**CITY OF ALBUQUERQUE  
PLANNING DEPARTMENT  
October 23, 2013  
DRB Comments**

**PROJECT # 1009853**

**APPLICATION # 13-70713**

***RE: Lot 6, Garden Acres***

PROJECT # 1009853  
 13-70713 (SK)  
 10-23-13

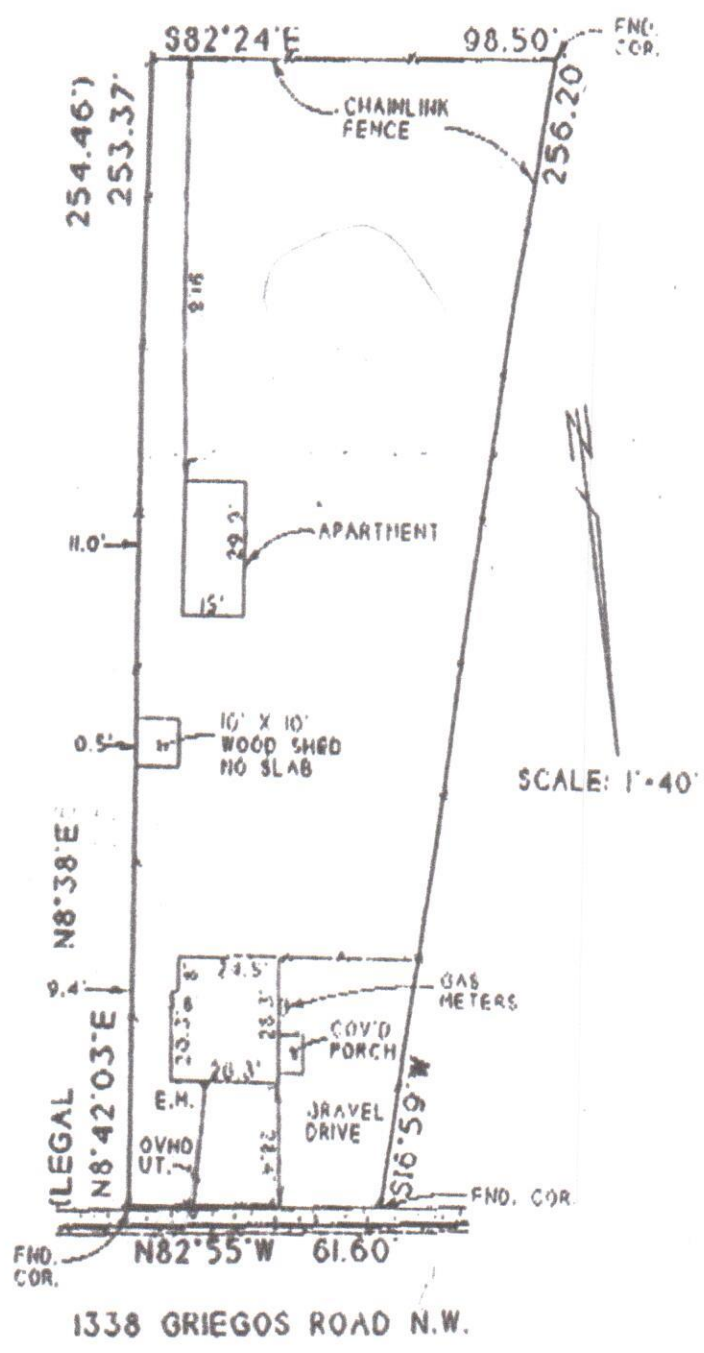
“Portions of” Lot 6 must be documented as having been created prior to the 1973 Subdivision Ordinance, or all of Lot 6 must be platted in order to conform to the ordinance.

It appears the property could be divided into two (2) lots. Minimum Lot area is 6,000 sq ft NET, which is exclusive of the required access easement – minimum 22 feet wide easement is needed to serve both the front and rear lot.
